Cc: Jamey Ayling <jamey.ayling@co.kittitas.wa.us>; Bradley Gasawski <bradley.gasawski@co.kittitas.wa.us>; Zach Torrance-Smith <zach.torrancesmith@co.kittitas.wa.us>; Ellie Myers <ellie.myers@co.kittitas.wa.us>
Subject: VA-24-00003 Tinoco & Agrella - Notice of Application

TO: All Staff
FROM: Public Works Plan Review Team
DATE: January 30, 2024
SUBJECT: VA-24-00003 Tinoco & Agrella

PROPOSED SITE PLAN

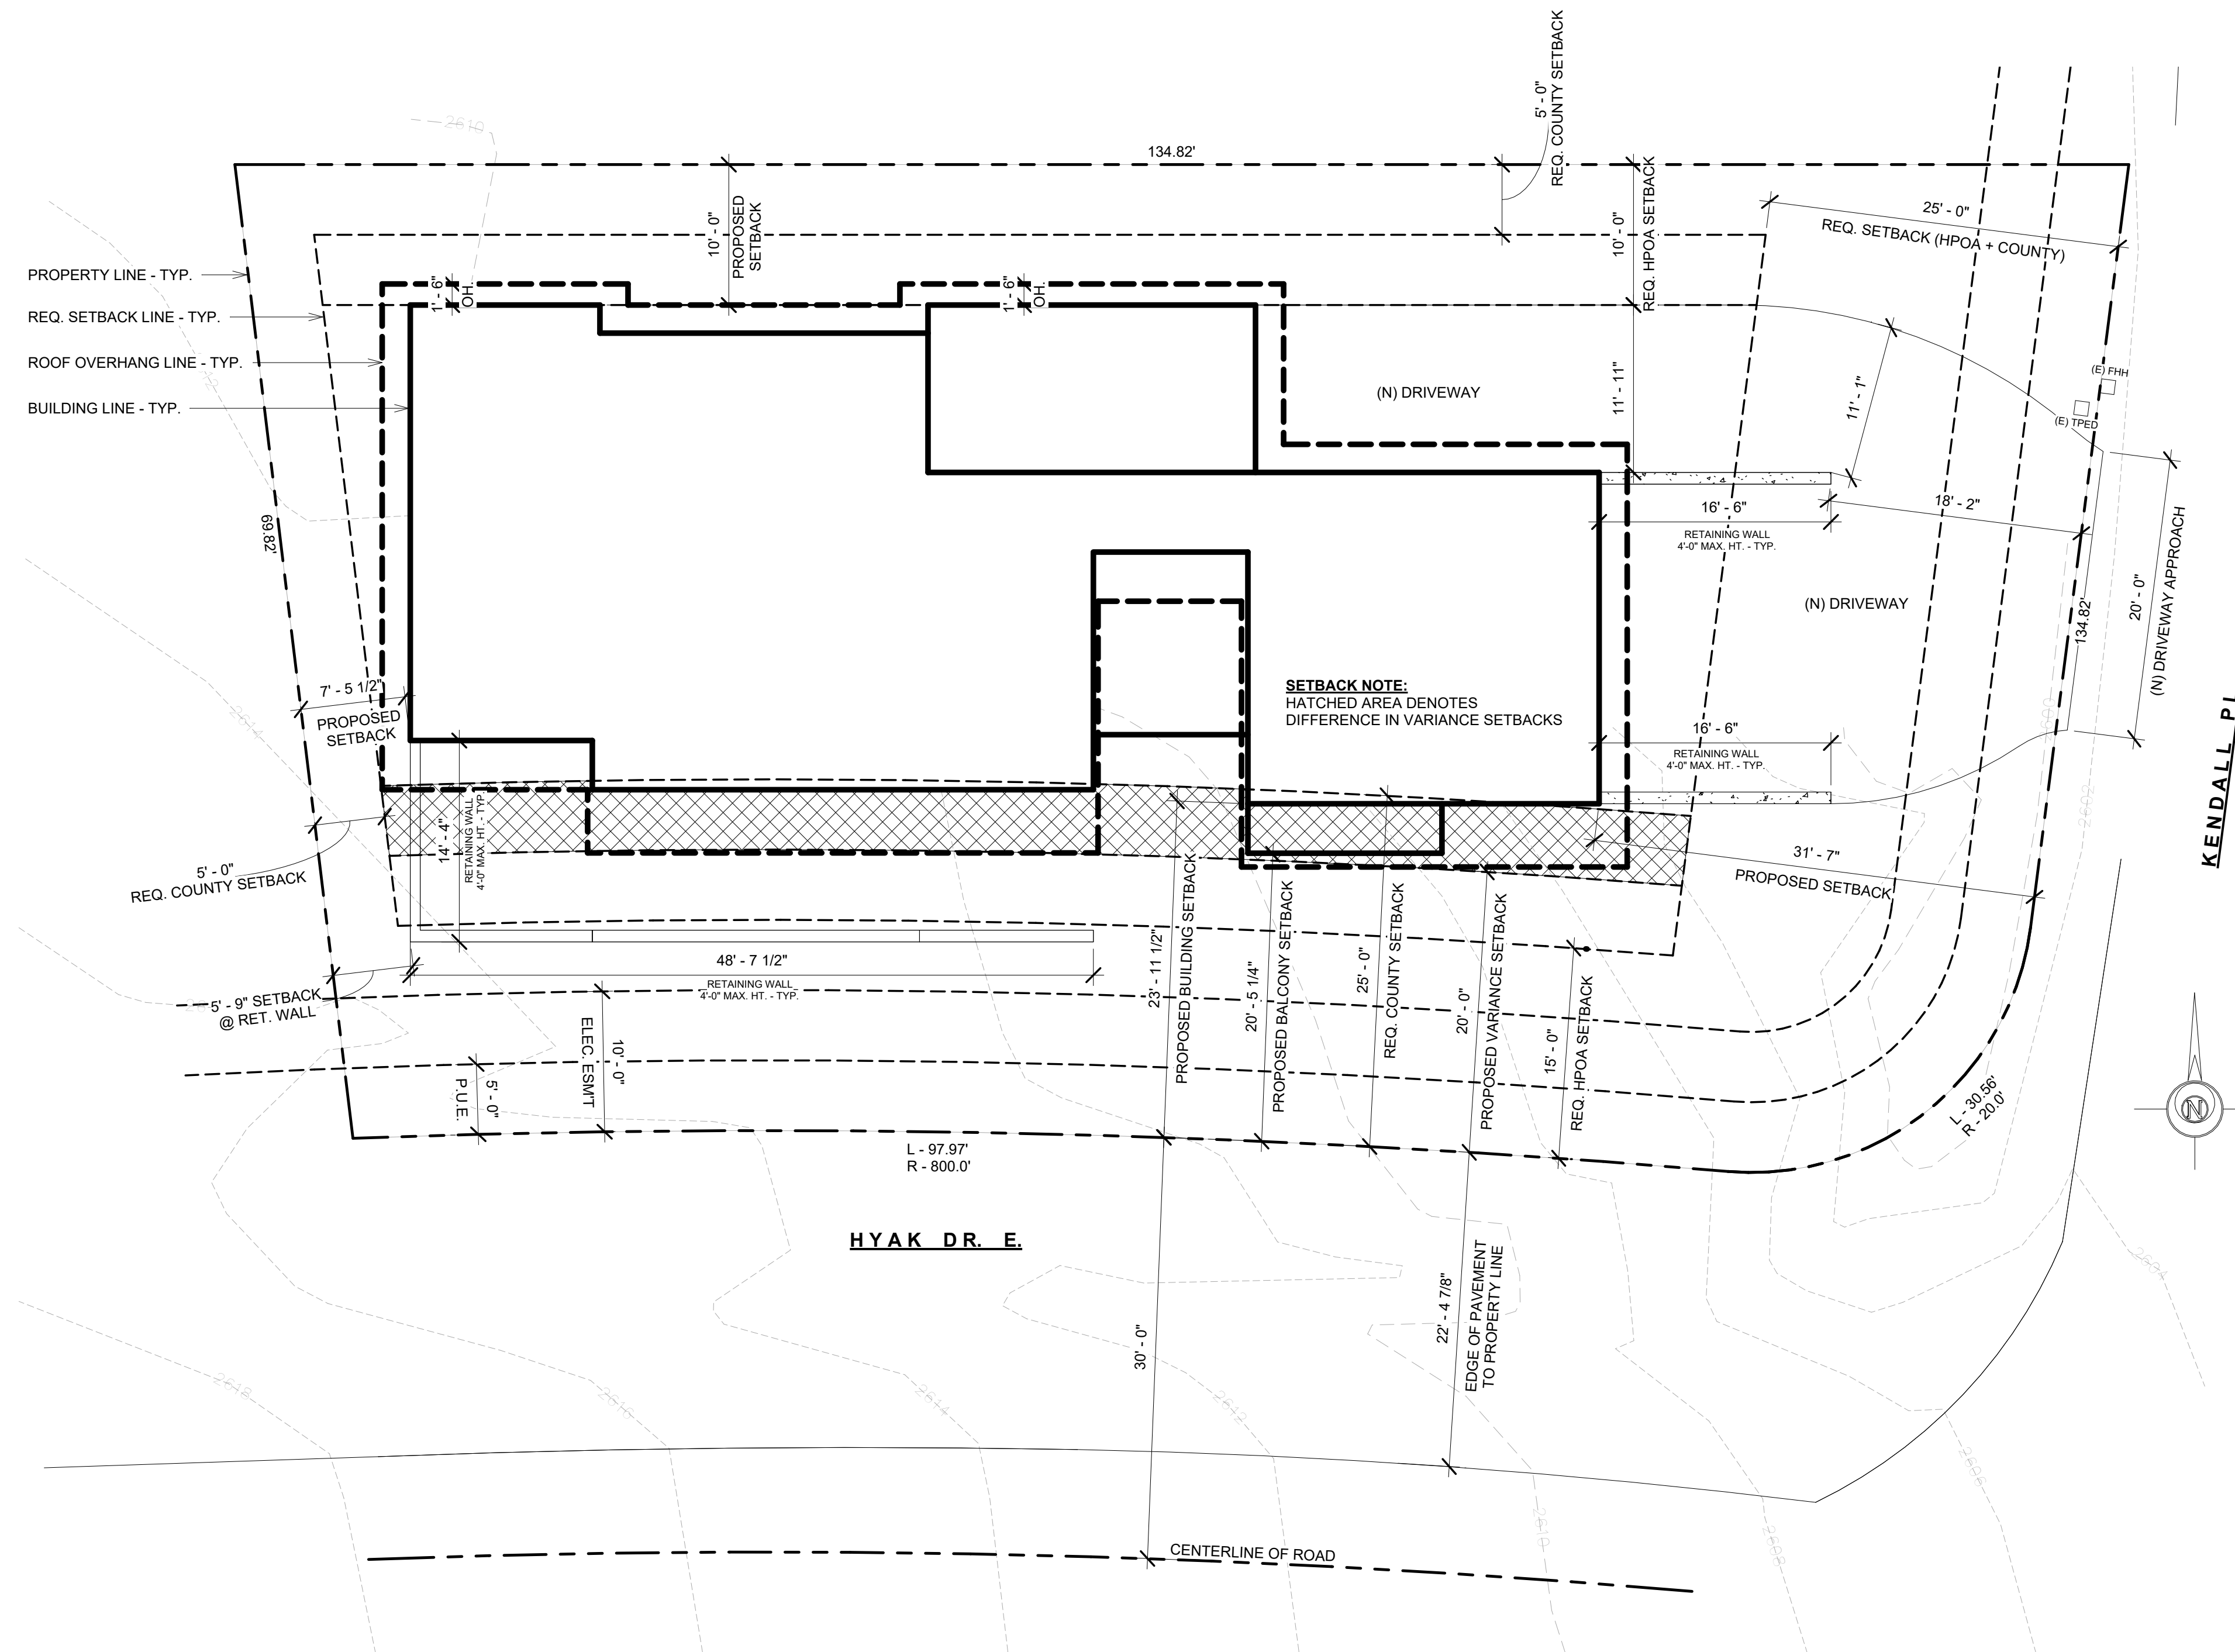
ACCESS	1. Applicant has an issued Access/Address Permit AA-22-00213 for a single-family dwelling on file with Kittitas County Public Works. 2. Maintenance of driveway approaches shall be the responsibility of the owner whose property they serve. The County will not maintain accesses. 3. Any further subdivision or lots to be served by proposed access may result in further access requirements. See Kittitas County Road Standards. 4. In addition to the above-mentioned conditions, all applicable Kittitas County Road Standards apply to this proposal. Access is not guaranteed to any existing or created parcel on this application. (JS)
ENGINEERING	Except as exempted in KCC 14.05.060, no grading or filling upon a site involving more than one hundred (100) cubic yards shall be performed without a grading permit from the County Engineer or Public Works designee (KCC 14.05.050). An application for grading in excess of five hundred (500) cubic yards shall be accompanied by an engineered grading plan (KCC 14.05.080). (CP)

PROPOSED FLOOR PLANS
MAIN HOUSE + ALQ.

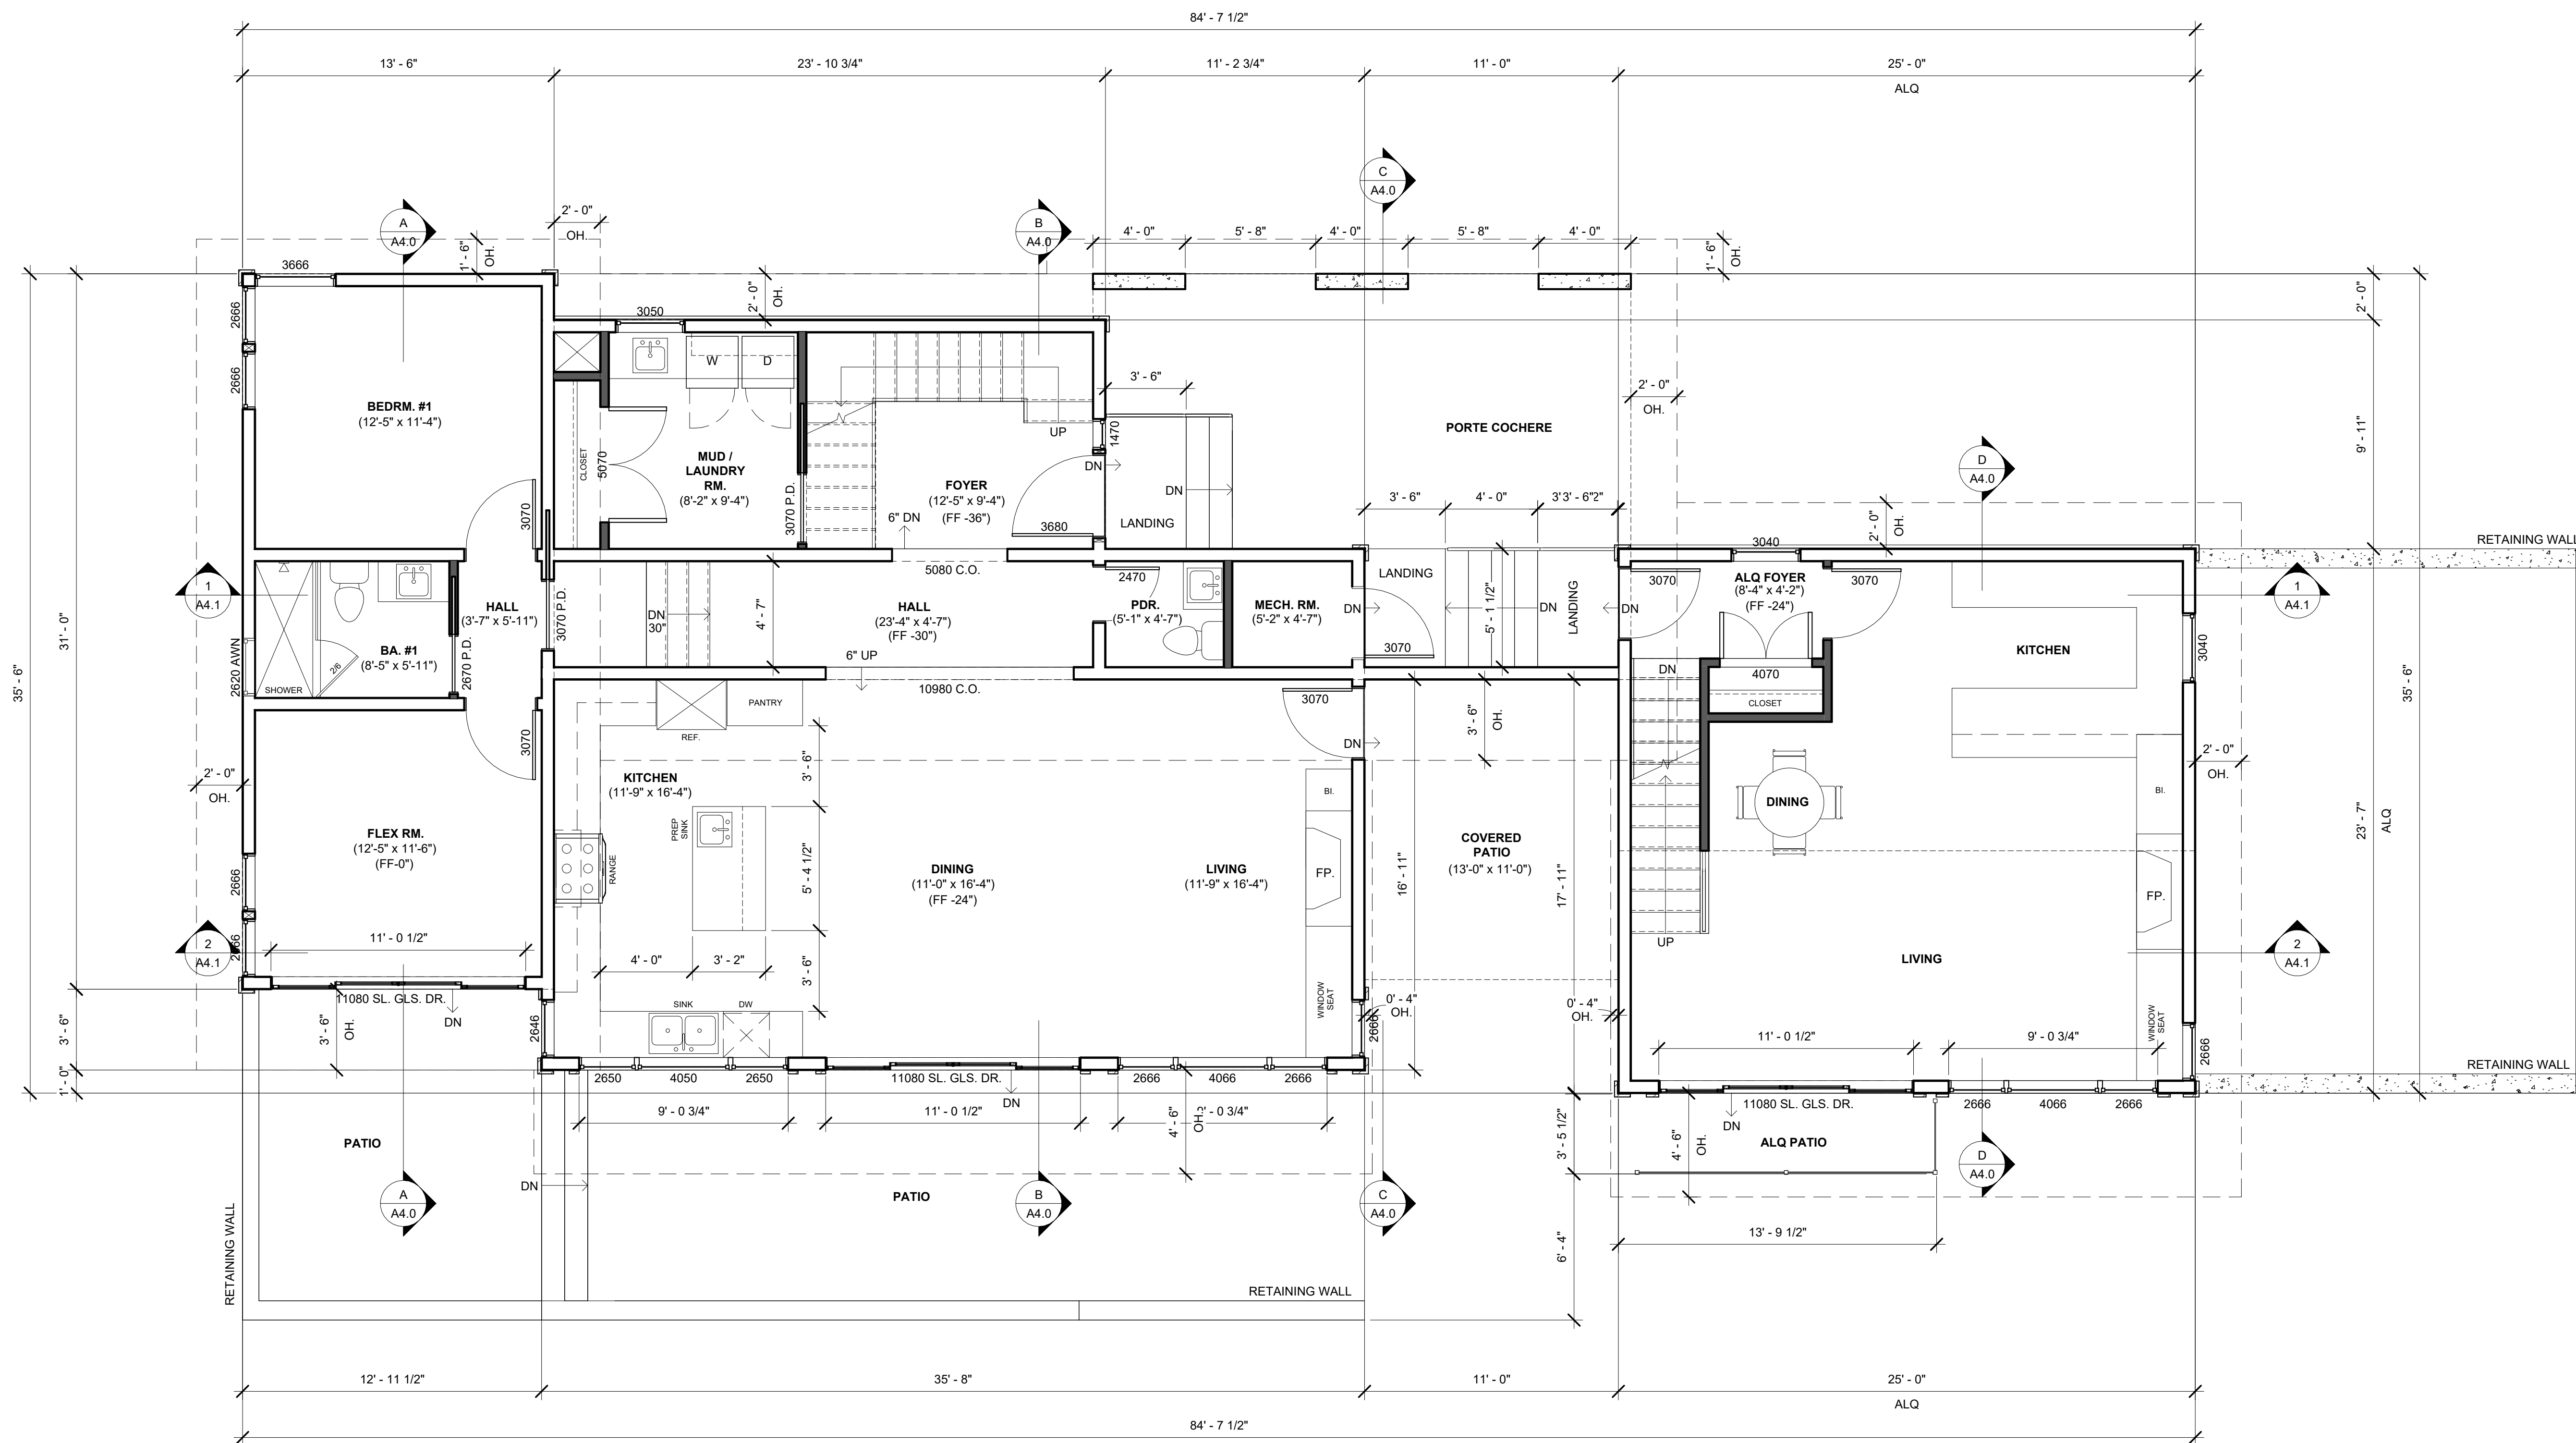
- How is drinking water being provided to this home and the second, on-site dwelling unit – private well or from a public water system?
- If the applicant's property is served by a public water system, the construction of the home and on-site dwelling unit constitutes two (2) connections, and this needs to be accounted for in the connection information (i.e., WFI) for the public water system.
